From: Anita Gardner
Sent: 05 December 2019 09:50
To: Shivani Bhardwaj [REDACTED]
Subject: RE: Pound Place - Report ref R18-12844 A/161/19/DOC

DRAWING TITLE:
PROPOSED
DRAINAGE LAYOUT
SHEET 1 OF 3

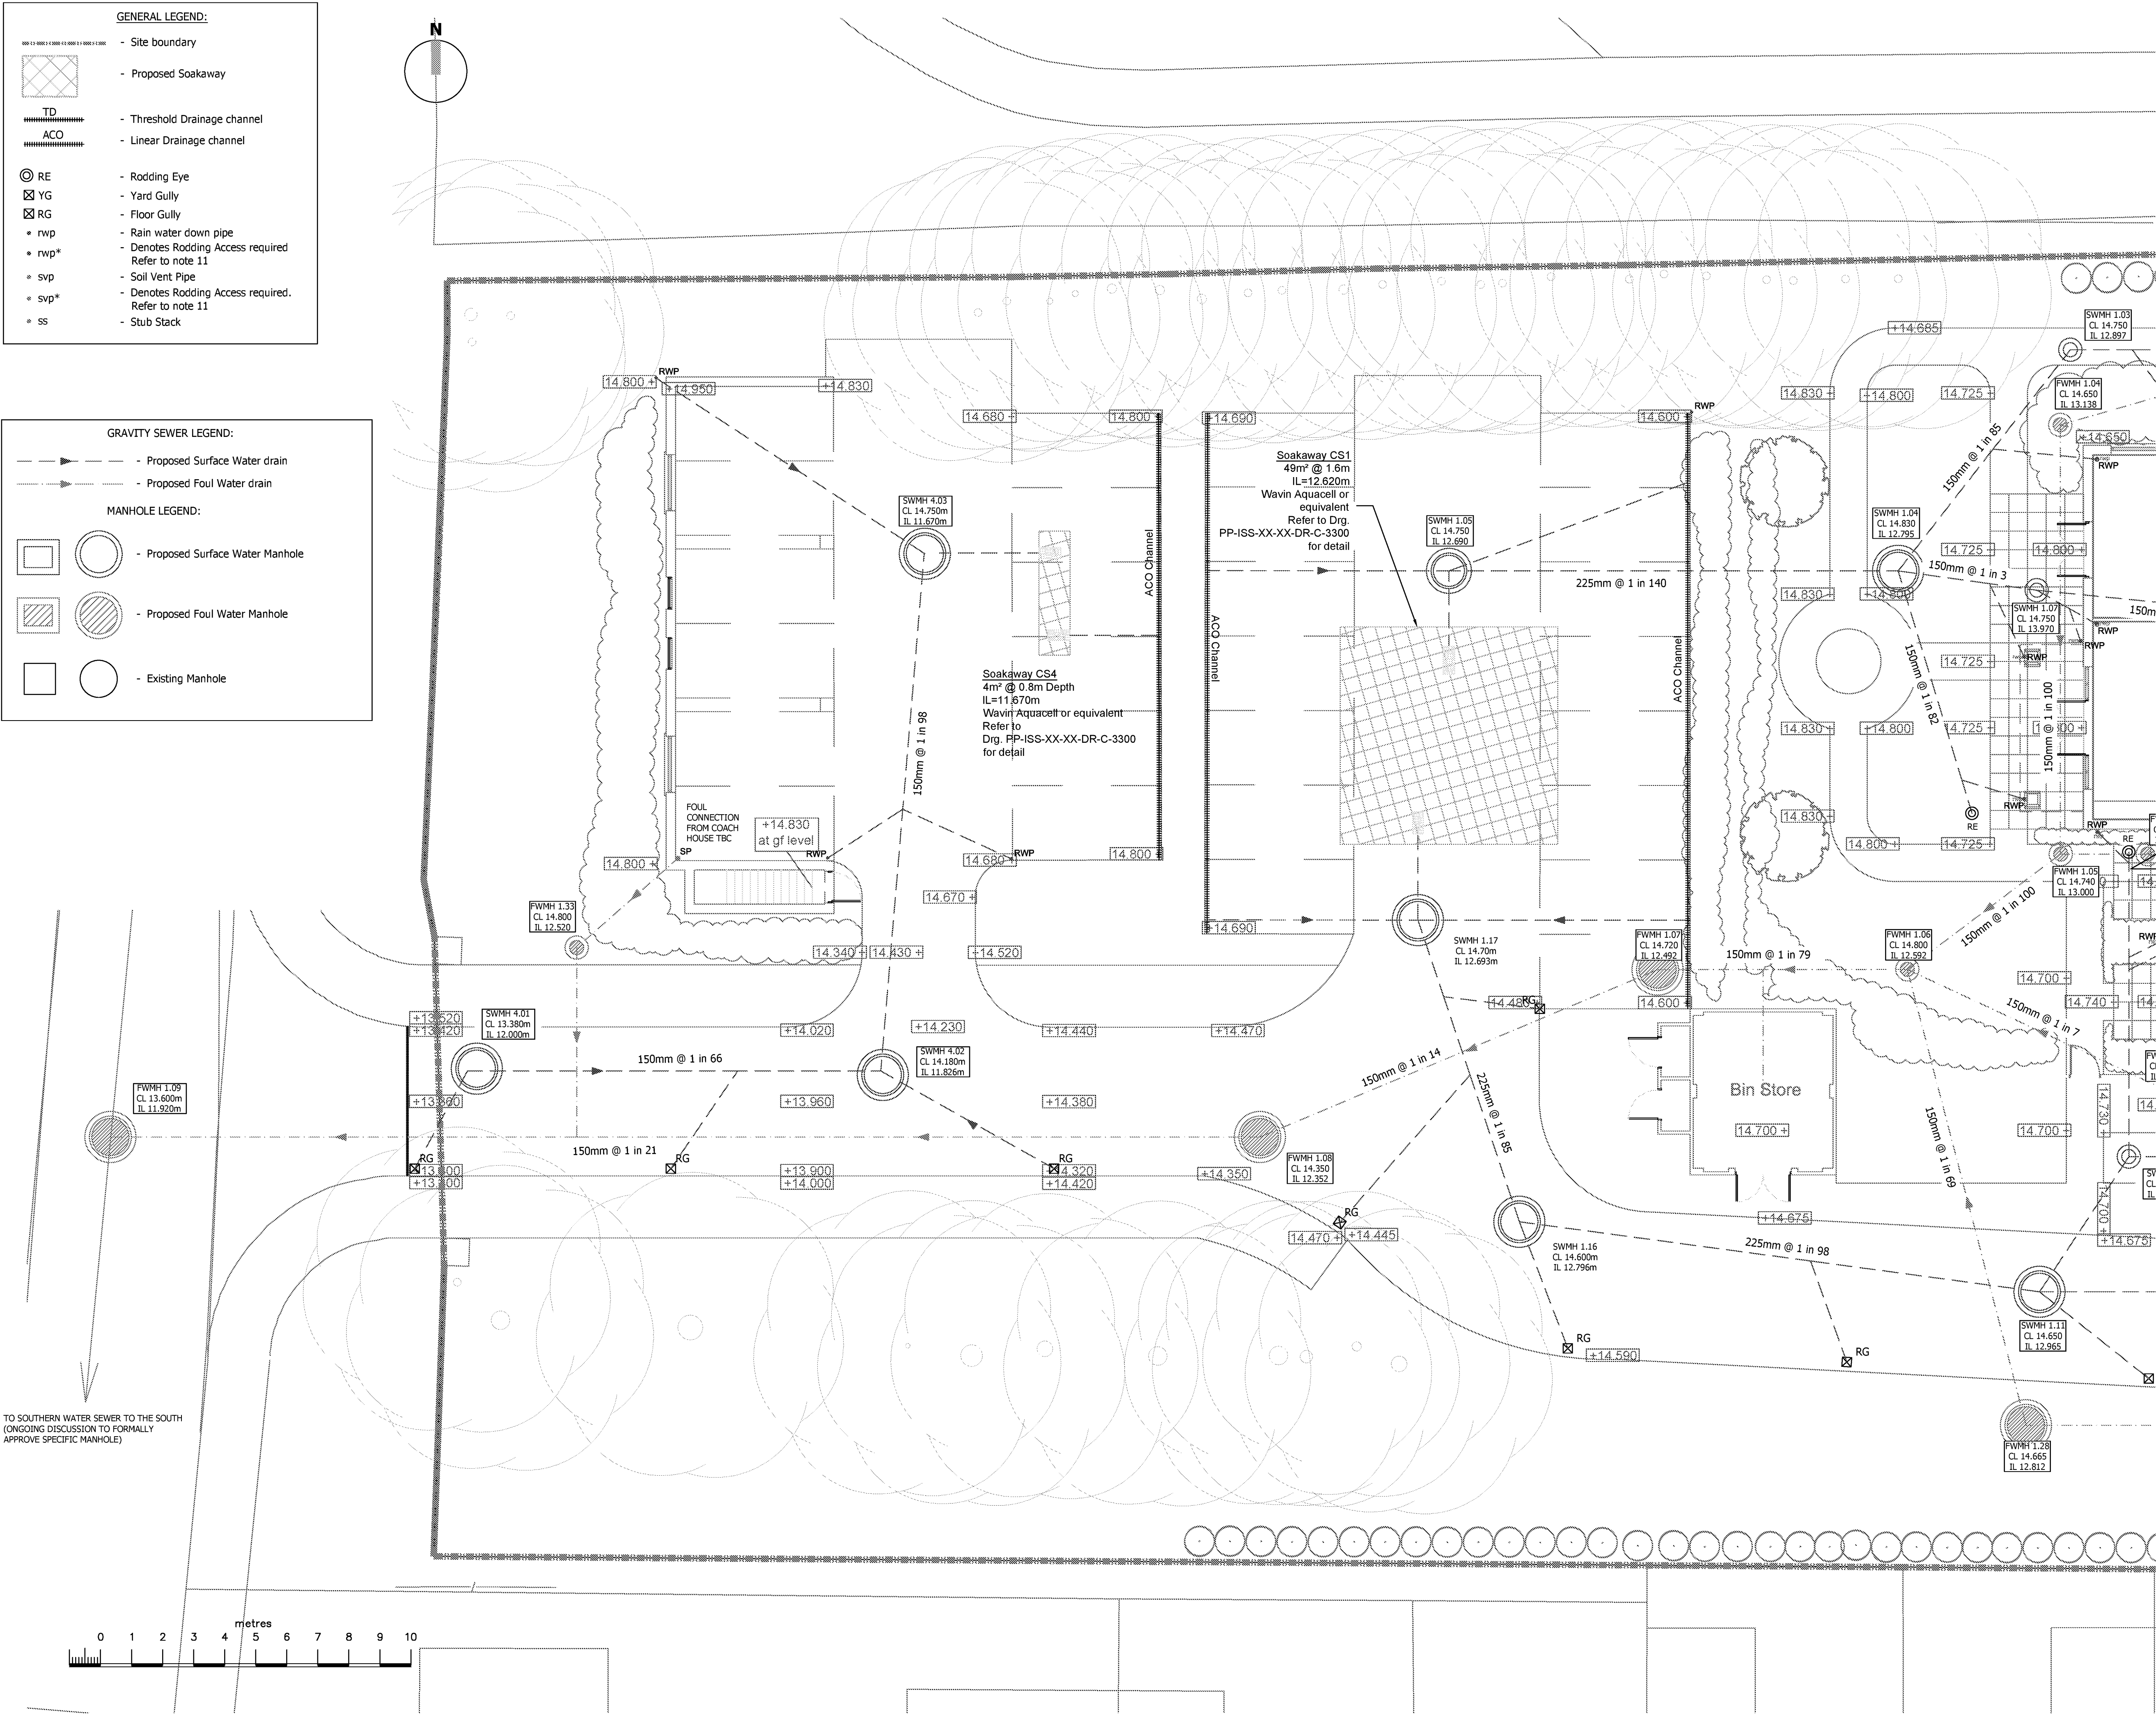
I am going to describe my findings below, (none of the soakaways have cover levels on the drawings so I have used the cover levels of the closest silt traps).

Soakaway CS1

Cover Level of Soakaway:	14.50m	
Top of the Tank:	13.75m	0.75mbgl
Invert Level (Base of Soakaway):	12.55m	1.95mbgl
TP01 Depth:		2.8mbgl
TP01 Fill Depths:		0.96mbgl (Test 3), 1.1mbgl (Test 2) 1.9mbgl (Test 1)

Soakaway CS4

Cover Level of Soakaway:	14.70m	
Top of the Tank:	12.67m	2.03mbgl
Invert Level (Base of Soakaway):	11.87m	2.8mbgl
TP01 Depth:		2.8mbgl
TP01 Fill Depths:		1.9mbgl (Test 1), 1.1mbgl (Test 2), 0.96bgl (Test 3)

Soakaway CS2

Cover Level of Soakaway:	14.65m	
Top of the Tank:	13.40m	1.25mbgl
Invert Level (Base of Soakaway):	12.20m	2.45mbgl
TP01 Depth:		0.9mbgl
TP01 Fill Depths:		0.5bgl (Test 1), 0.54mbgl (Test 2) 0.51mbgl (Test 3)

Soakaway CS3

Cover Level of Soakaway:	14.74m	
Top of the Tank:	13.80m	0.94bgl
Invert Level (Base of Soakaway):	12.20m	2.54bgl
TP01 Depth:		0.9mbgl
TP01 Fill Depths:		0.5bgl (Test 1), 0.54mbgl (Test 2) 0.51mbgl (Test 3)

Samples and In Situ Testing show that slightly gravelly stratum starts at 0.35mbgl however there is no samples below 0.9mbgl. In addition this soakaway is closer to WS05 which exhibited very stiff clay down to a depth of 1.8mbgl.

However, I am concerned that the depth of the infiltration test on the west of the site does not reflect the depth of the soakaways proposed there. As previously stated the pit dimensions here were also undersized (0.3m x 0.3m). Nor is there sufficient samples and in situ testing to justify an assumption on the deeper ground conditions. Indeed WS05 (which is in proximity to CS3) exhibits very stiff clay which could affect infiltration rates.

It is suggested that the applicant completes a repeat of the infiltration tests to correspond with the locations and depths of CS3 and CS4. If they only wish to complete one trial pit it will be acceptable for them to locate this at the location of CS3 to a depth of 2.5mbgl, as the infiltration rate is likely to be slower due to the expected presence of clay."
